Ribble Valley Borough Council  
Church Walk,  
Clitheroe,  
BB7 2RA

<b>Proposal:</b>	Discharge of condition 2 - revised footways and parking bays, 3 - walling and roofing materials, 4 - landscaping and 5 - renewable energy of planning consent 3/2009/0399
<b>Location:</b>	Land adj 34 Kirklands Chipping
<b>Grid Ref:</b>

The Highway Development Control Section has made the following comments regarding the discharge of condition 2 (revised footways and parking bays): -

Client:	KEEPMOAT		
Job:	KIRKLANDS, CHIPPING		
Drawing title:	SITE LAYOUT		
Drawing Number: (Job number)	M3792	100	Revision: C
Scale:	1:100@A1		
Date:	FEB 15		
Drawn by/ checked by:	MCS

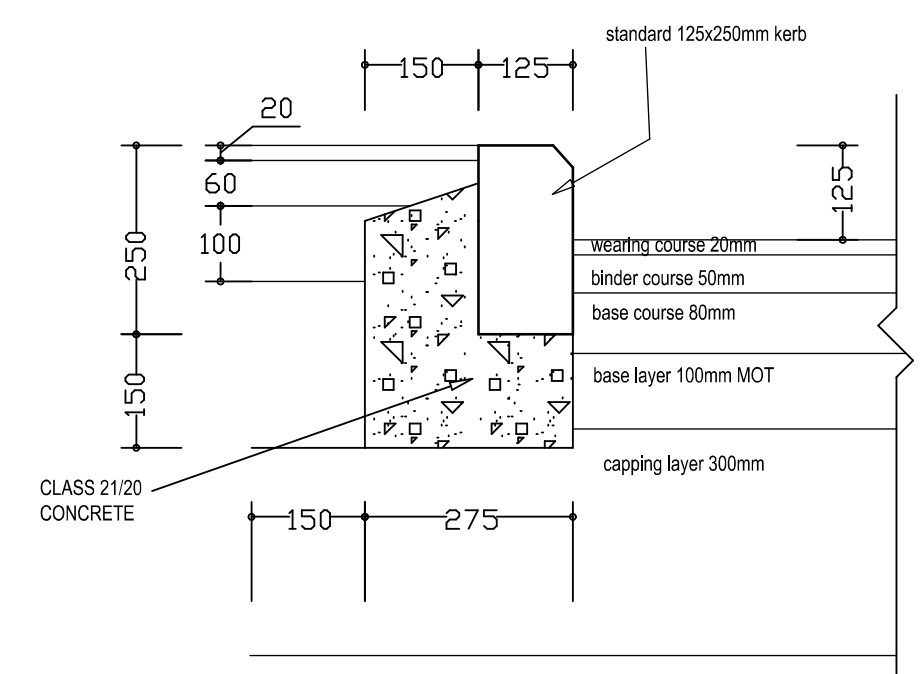
1. The car parking associated with the single car parking space, provide a 3.0x3.0m sight line from the centre of the drive to be back of the footway, to provide safe vision of pedestrians passing the parking bay.
2. The car parking associated with the single car parking space to have a minimum clear width of 2.6m, to provide additional room to open the doors if fenced in.
3. Each car parking space associated with 14 Club Row to be a minimum of 2.4x4.8m and provide sight lines to allow views of passing vehicles and pedestrians within the forecourt.
